Ribble Valley Borough Council

App no: 25.0852

**Address: BAE Systems Samlesbury Aerodrome Myerscough Smithy Road
Balderstone BB2 7LF**

**Proposal: Proposed erection of three-storey (12m high) modular office building
of 7026 sq m with associated car parking, cycle parking and
landscaping**

**1 ST - Proposed Site Plan**

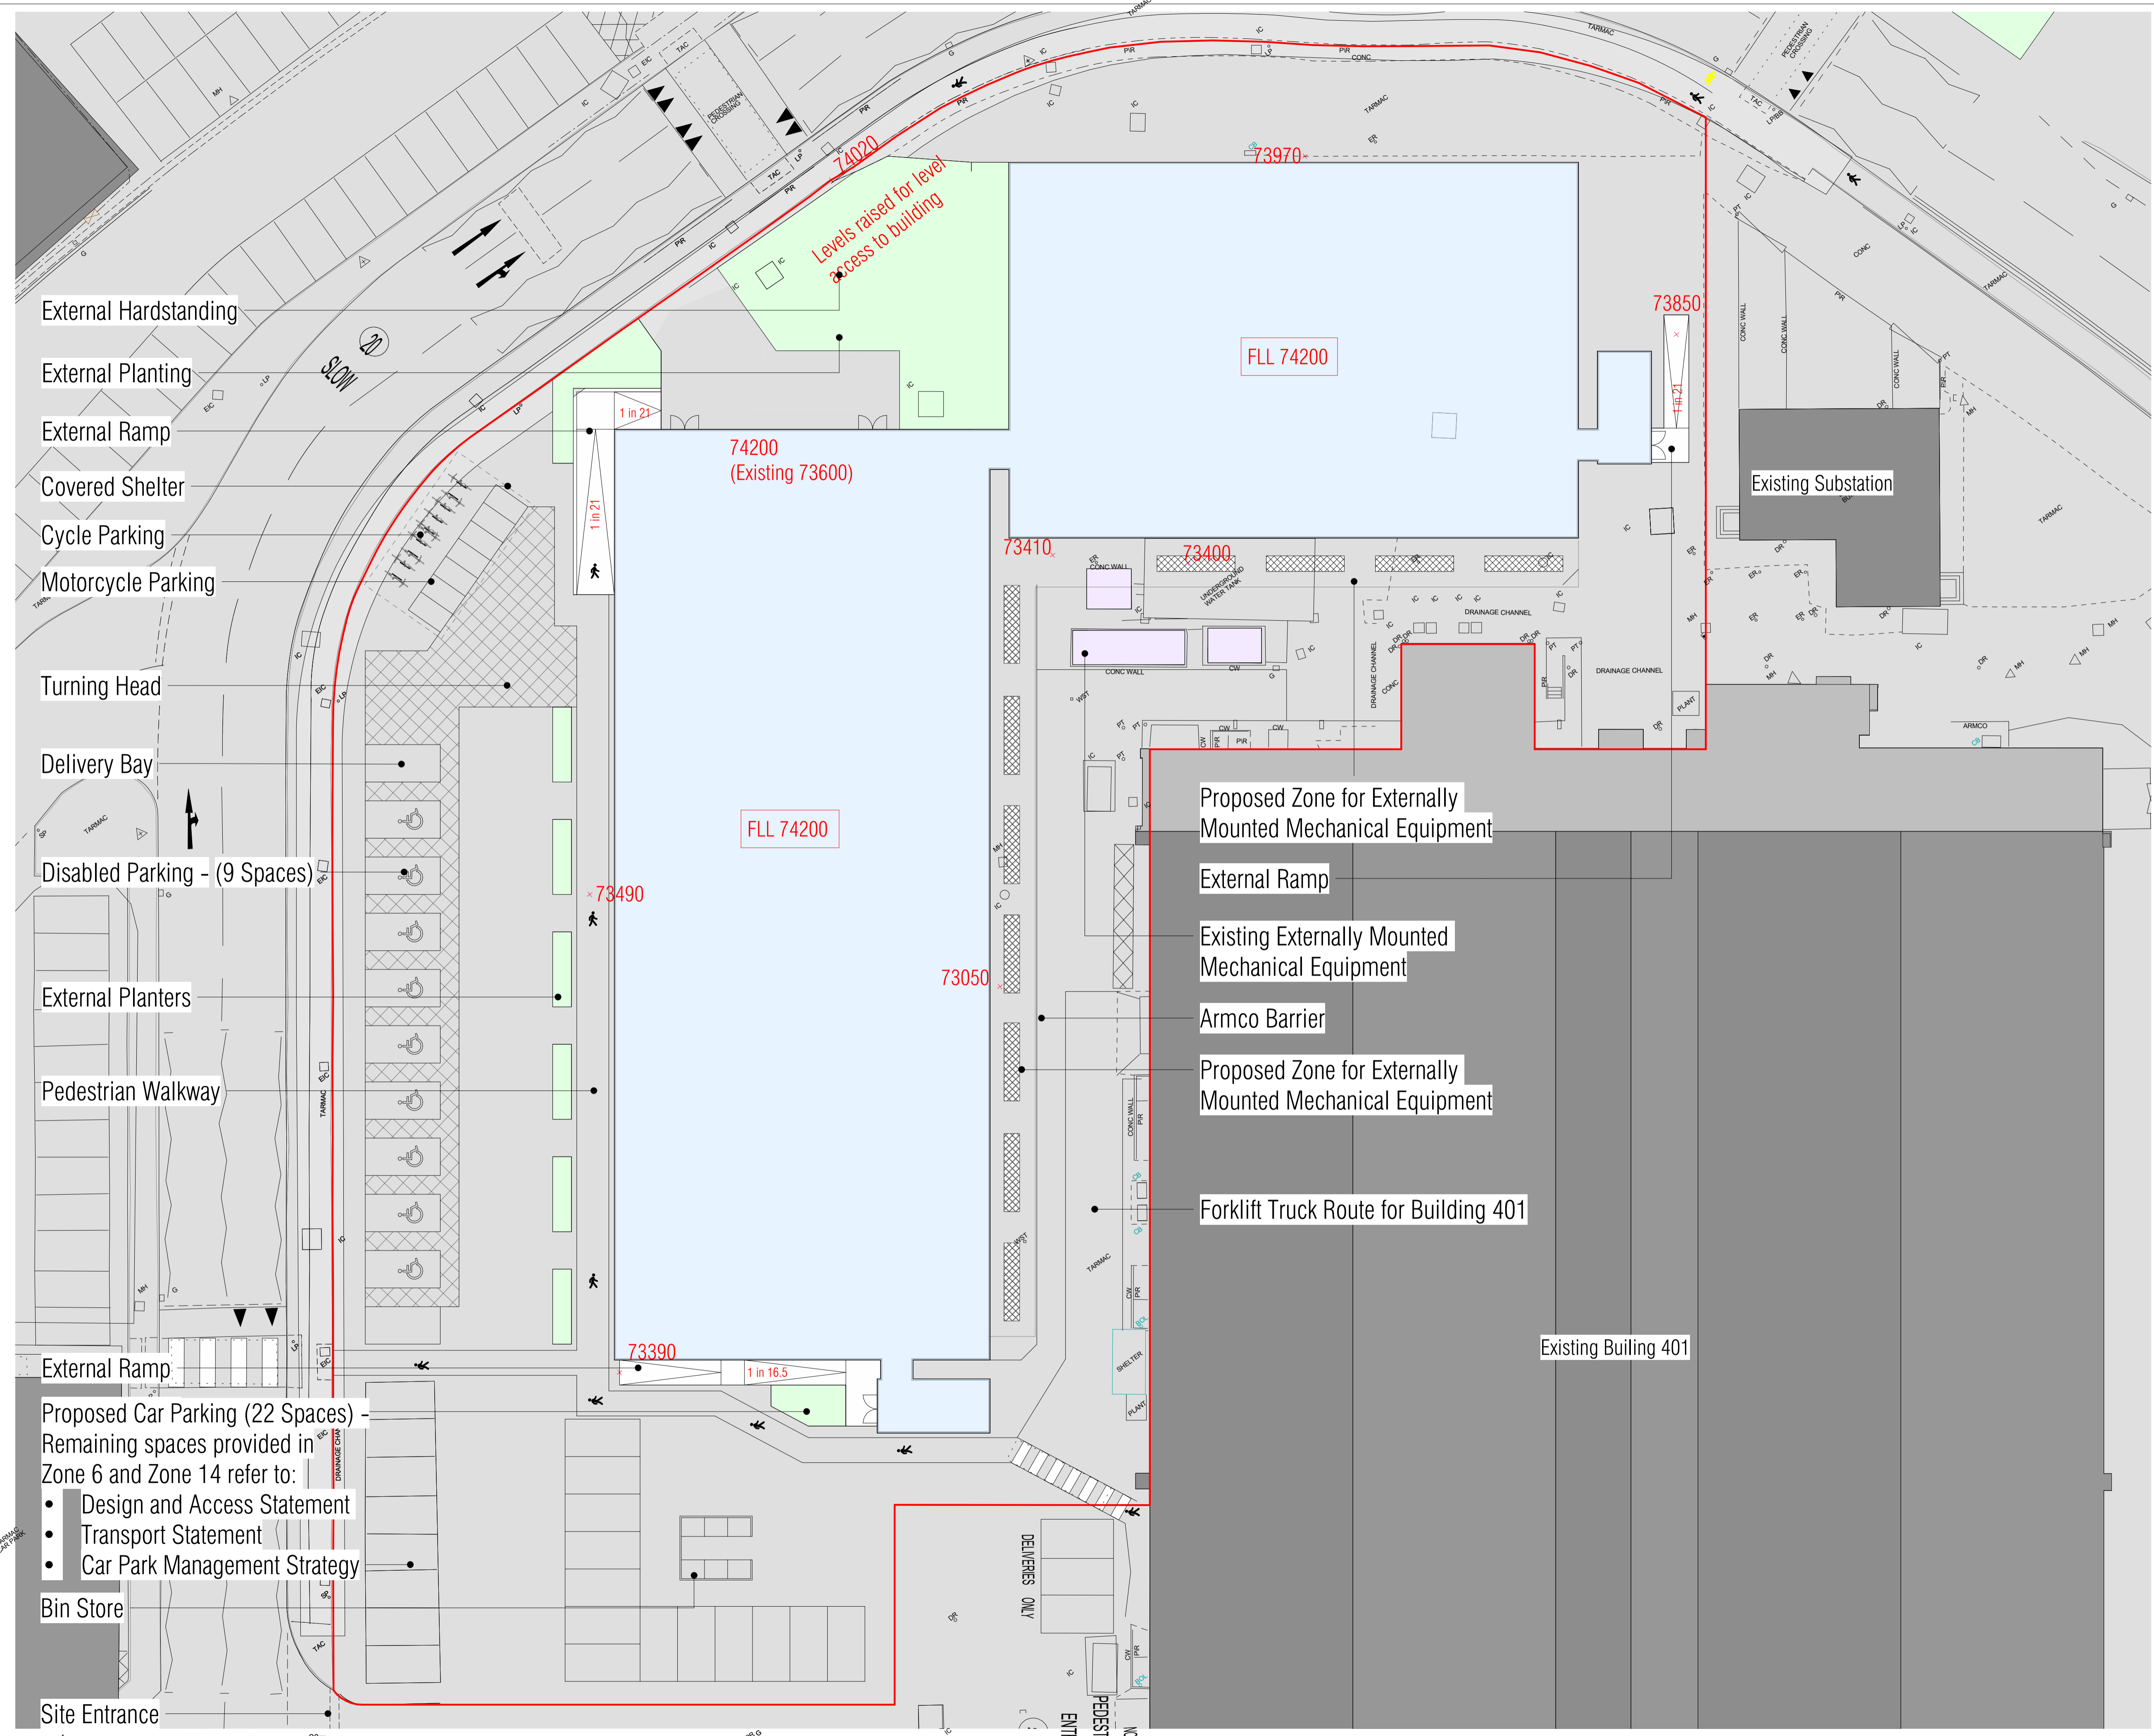
There are 175 spaces proposed for the office building comprising of 22 spaces on a new re-lined car park to the west of the site and 153 spaces on existing parking areas in zones 6 and 14.

The new car park includes 9 accessible spaces, 7 covered motorcycle and 18 bicycle spaces proposed. There are shower and changing facilities provided to support sustainable travel which is supported.

We would request electric vehicle charging provision is provided.

Based upon a Class E (g)(i) formally B1 facility of 7026sqm we would expect to see a parking provision of 146 spaces, with a reduction applied due to being a highly accessible site with on-site facilities.

We would consider the car and cycle parking provision to be acceptable.

1. Prior to first use of the development hereby permitted the car and cycle parking shall be provided in accordance with the approved plan. Reason: To provide adequate car and cycle parking on site.

1 ST - Car Park Location Plan
1 : 2500

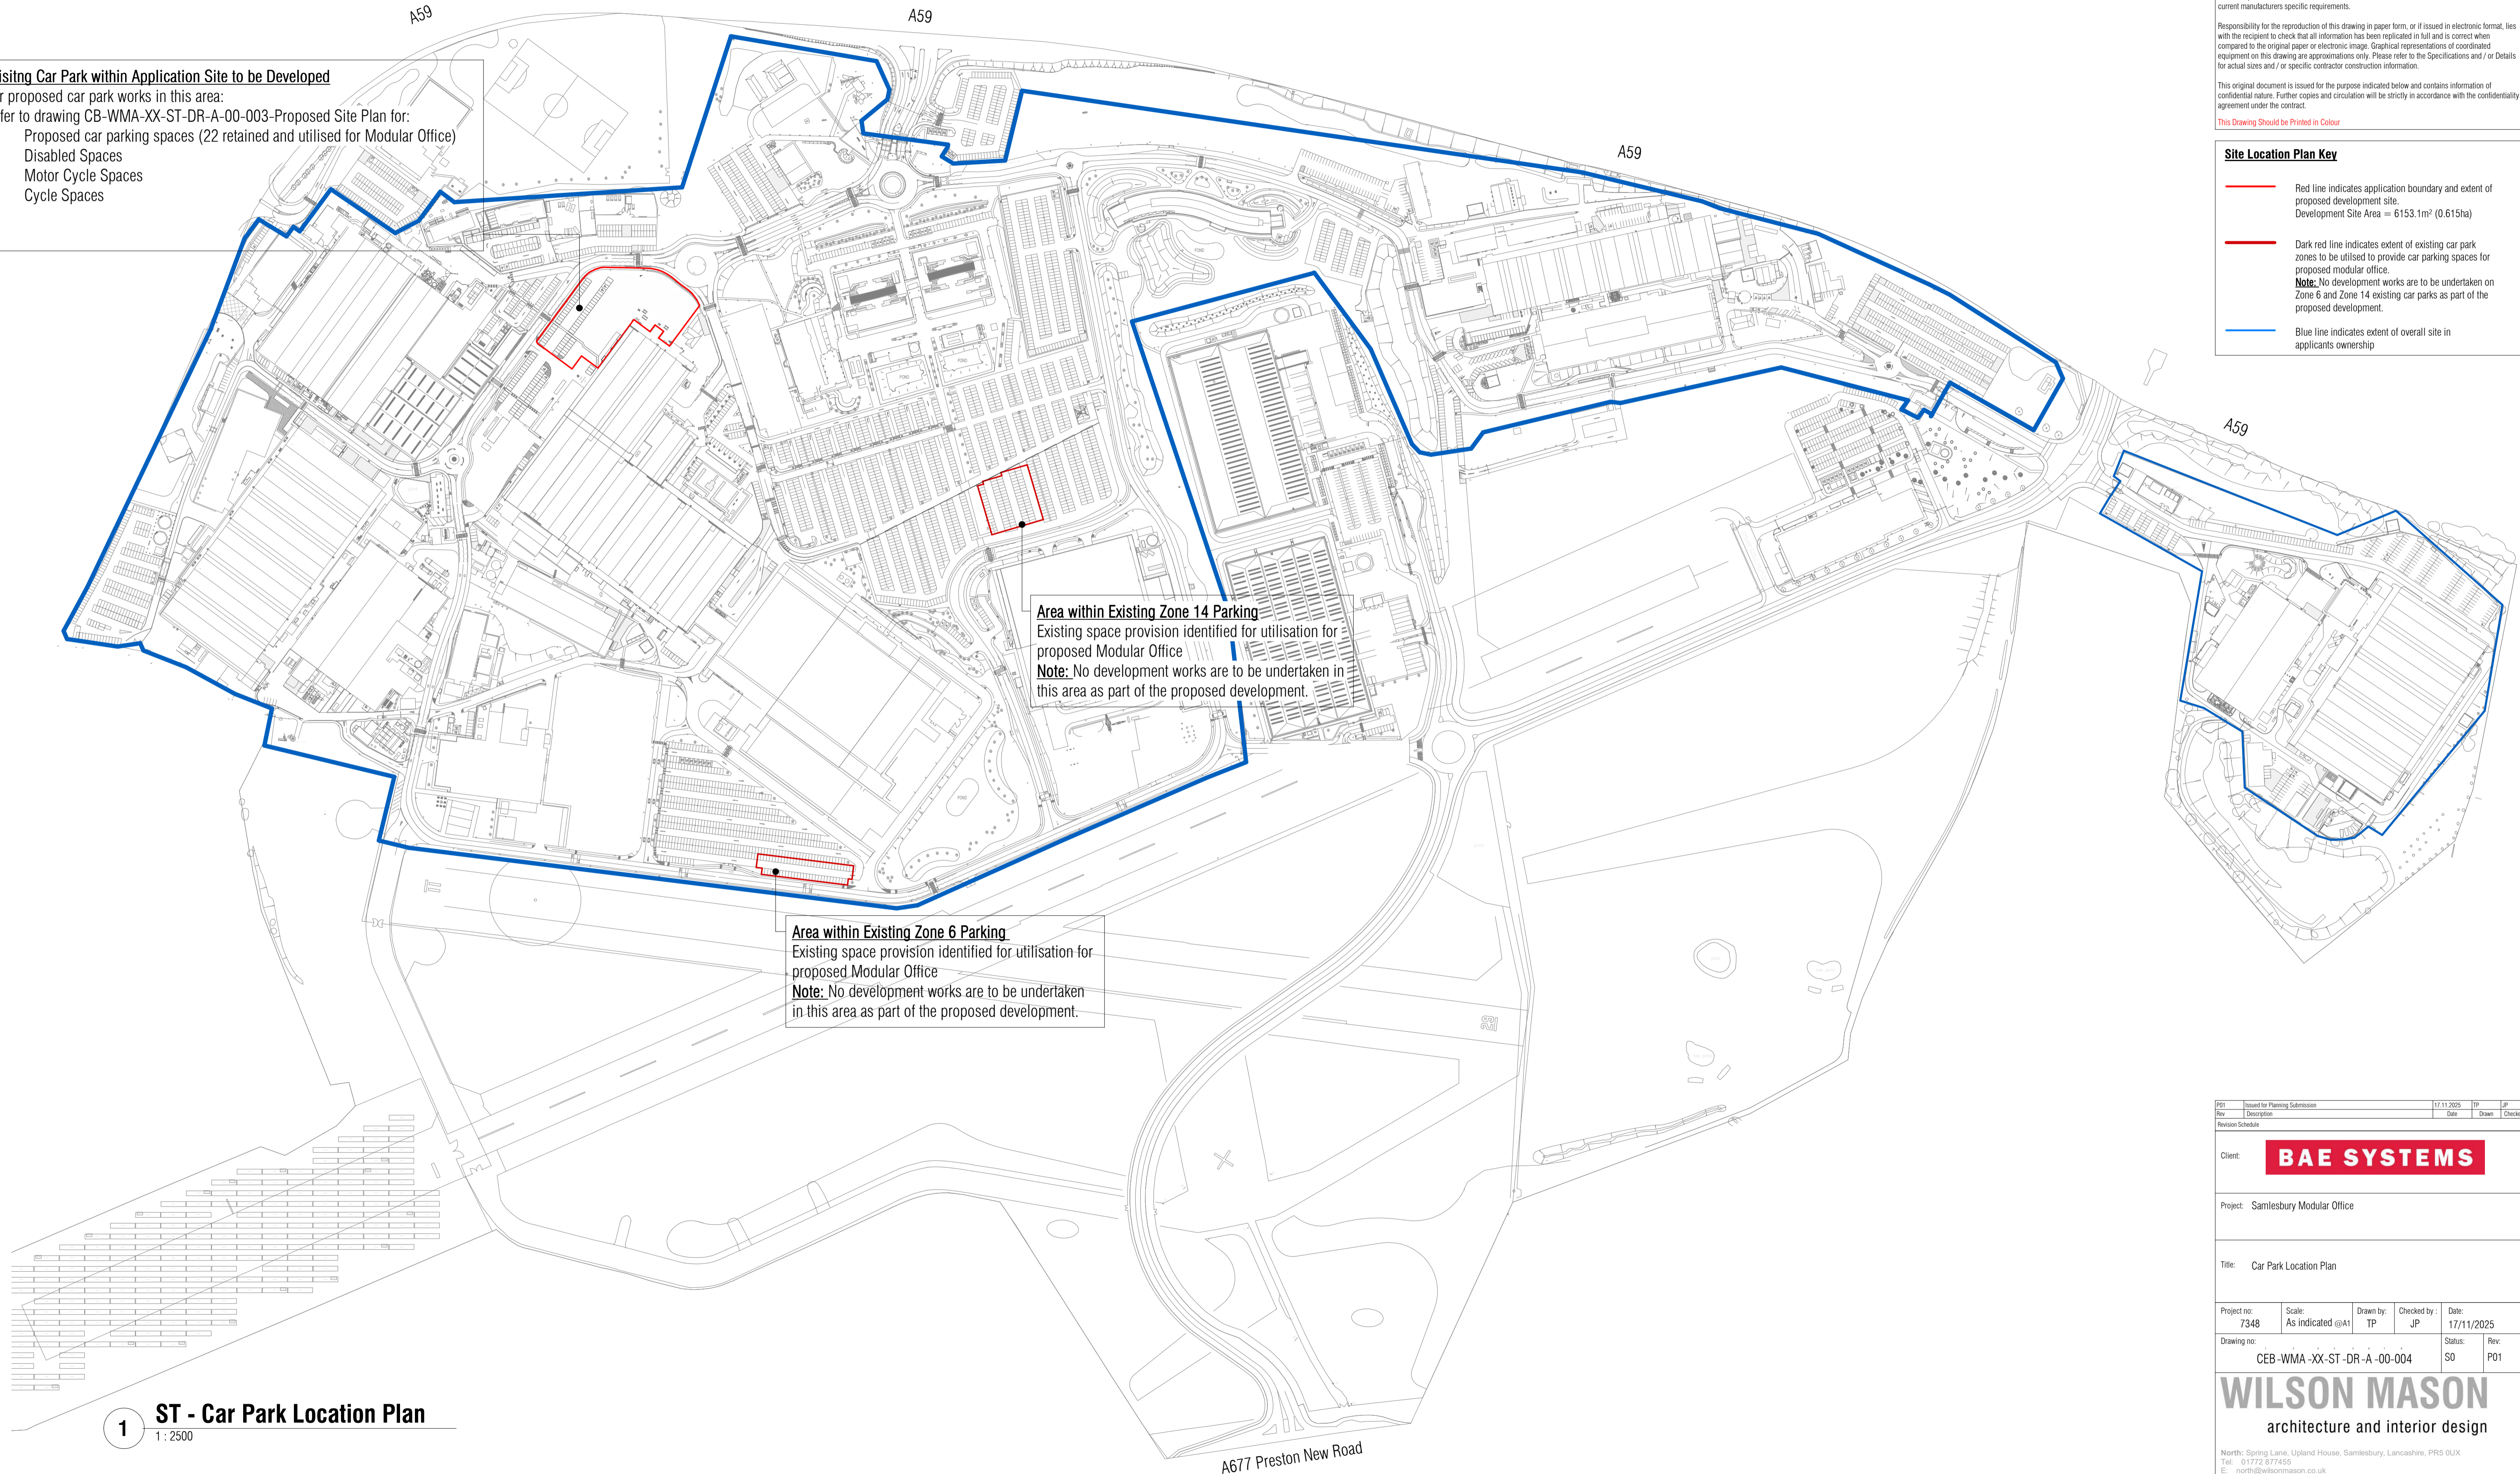
The BAE Systems Transport Committee monitor car parking across the wider site with 4056 parking spaces in total. Staff are not allocated parking and a first come first served system operates.

Zones 6 and 14 car parks were identified as being under used and were surveyed over a 4-week period to confirm sufficient spare capacity to accommodate the parking standard.
